20th March 2024

Removal of existing single storey rear extension and rear/side chimney stack. Erection of part two-storey, part single storey rear extension to 215 Stansted Road, Bishop's Stortford.

Following the refusal of the application ref. 3/23/2335/HH, we have submitted a revised application seeking approval for the extensions and alterations to the above property.

drawing No.
201.03A

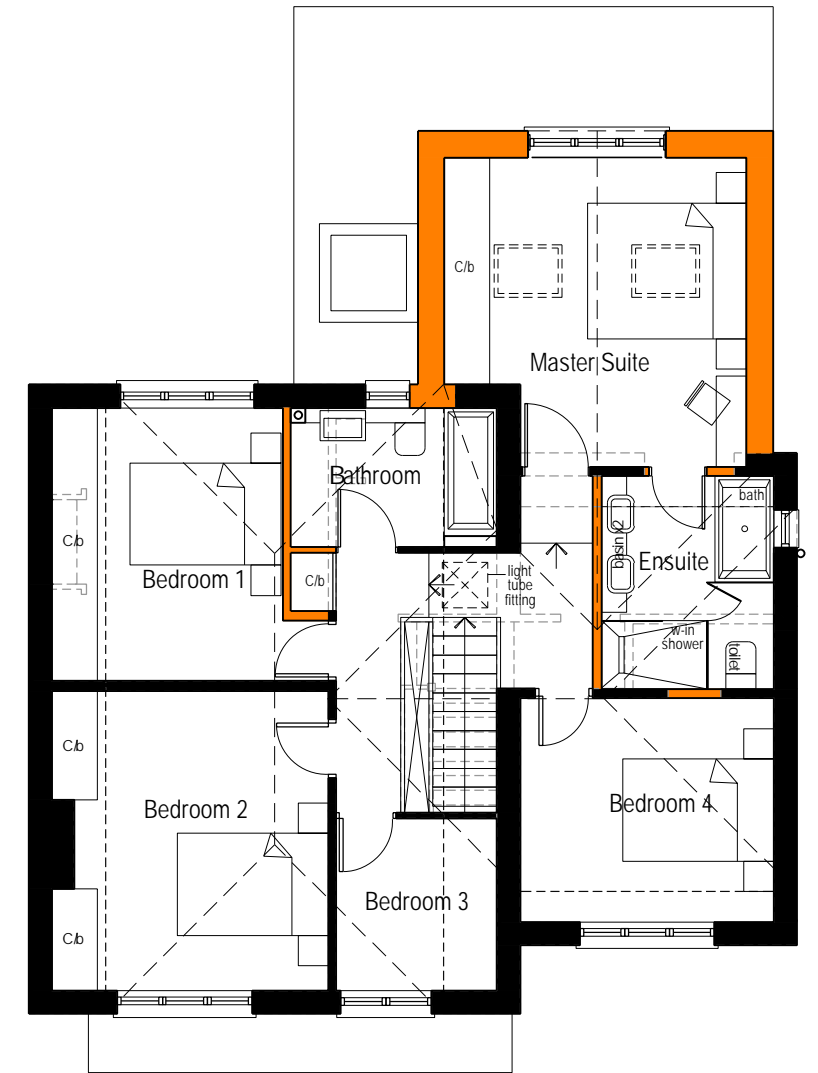
- 1. I would not be able to give specific depth of the extension. However, its relation to the existing dwelling should be considered. For example, when considered from the side elevation, the previously refused extension appears to almost double the depth of this elevation. This flank wall would be a prominent addition, particularly in the context of the rear of the property.*
- 2. To achieve a less overbearing design, the eaves could meet those of the host dwelling. It is noted that the eaves are overhanging and perhaps this design could be reflected to maintain character and appearance. Furthermore, it is considered that the refused scheme proposed a new gable whereas the existing roof is hipped. This was not necessarily unacceptable; however this could be further considered within any new design.*

The side elevation has been reduced in height, mass and appearance by dropping the proposed eaves to the existing lower eaves. The first floor rear wall has been pushed back 1.65m from the face of the ground floor extension. The first floor finish has been changed to facing brickwork complimenting the host dwelling. These changes have reduced the length of the extension (at the top) which also will reduce its presence onto Cannons Close (which will also be minimal as explained in the first points above).

drawing No.  
201.04A  
rev

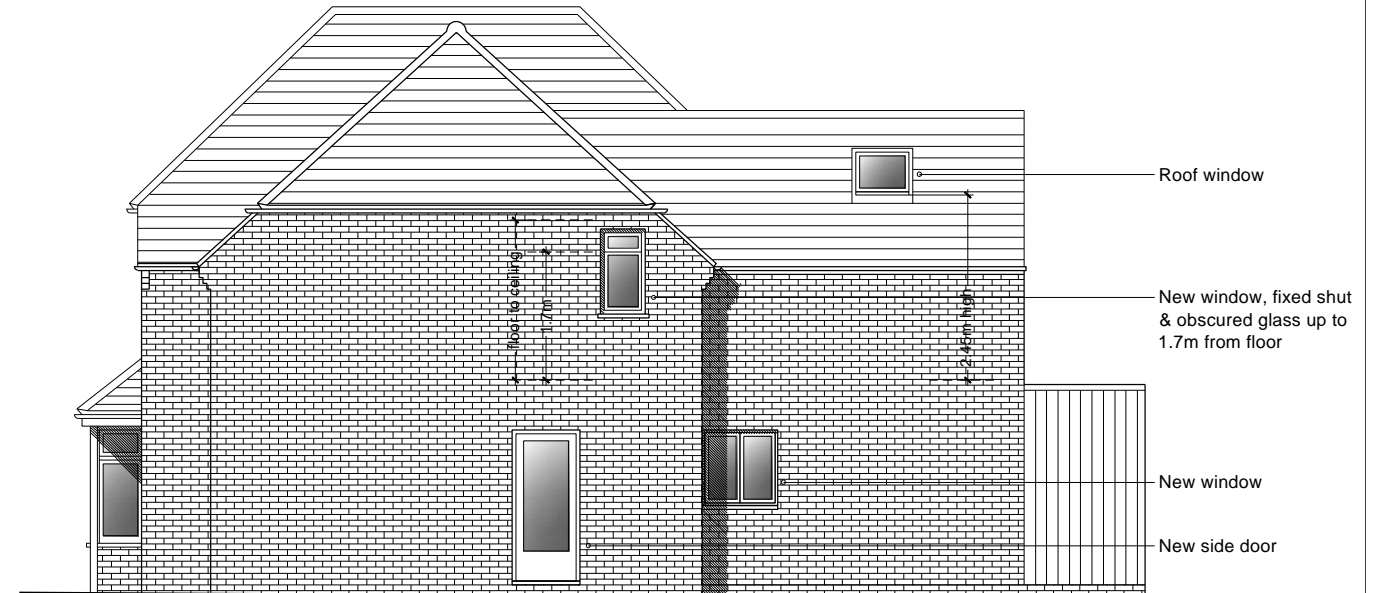
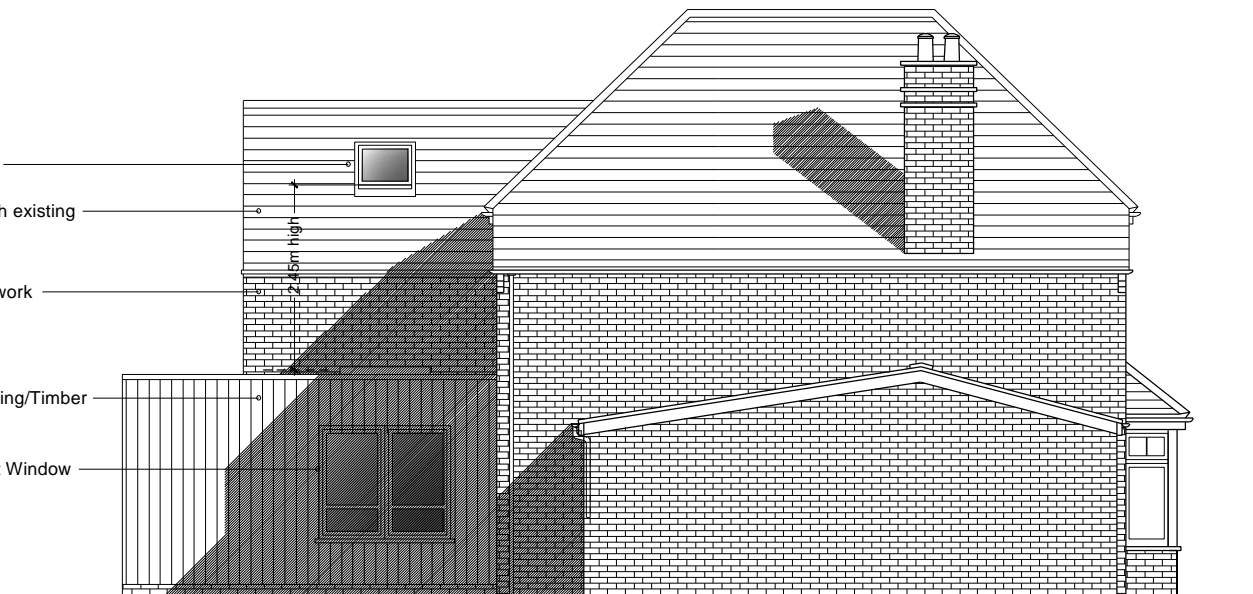
“It is considered that the size and design of the proposed extension would create a dominating and incongruous addition which appears overly prominent within the area to the detriment of the character and appearance of the street scene.”

- 3. The use of materials would also depend on the size and prominence of a proposed new scheme. For example, a much smaller proposed extension could potentially use differing materials as it may not appear incongruous from the view of the dwelling. However, when larger extensions are proposed, the materials and design take a greater importance due to their visibility and ability to dominate a property.*

- 4. This statement within the report related to the external finishes of the windows. It would have been to ensure that mis-matching windows were not placed to a readily visible elevation of the proposed extensions.*

The size of the proposed two storey element has been reduced by setting it back 1.65m from the face of the ground floor extension and its material has been changed to facing brickwork, complimenting the existing brick facades of the host property. Additionally, to this, the proposed eaves have been dropped to the lower eaves’ level off the host dwelling which results also in a new low level ridge line for the first floor rear extension at approx 6.5m from the ground (500mm less than under ref. 3/23/2335/HH. This ensures that the size and design of the proposed extension are not over-dominating or an incongruous addition preserving the character and appearance of this back-street scene. The single storey element has been retained in cladding as it will not be seen from Cannons Close as demonstrated in the images above.

The new first floor section retains a gable end design as this will maintain a straight roofline on the inside of the new Master Bedroom (avoiding an awkwardly complicated hipped roof construction) as this will now not be prominent from Cannons Close due to its new positioning with its eaves and ridge line considerably lower than in the refused scheme ref.3/23/2335/HH.

The amended scheme presents a change in the materials for the extension by dividing it in the two storey and the single storey parts with facing brickwork to the two storey and weatherboarding/timber cladding to the single storey which will not be seen at all from Cannons Close (as demonstrated in the first points above). This ensures that the few glimpses of the proposed first floor viewed from Cannons Close will have facing brickwork and matching tiles, all in keeping with the host dwelling.

In this amended application, it has been proposed to replace all existing windows to double glazed powder coated alu-clad windows and new rear doors will also be double glazed, powder coated aluminium doors. The front door has been proposed to be replaced with a new solid door and double glazed fixed side light. In this way, all new windows and doors will match in material and appearance as shown in the proposed elevations.
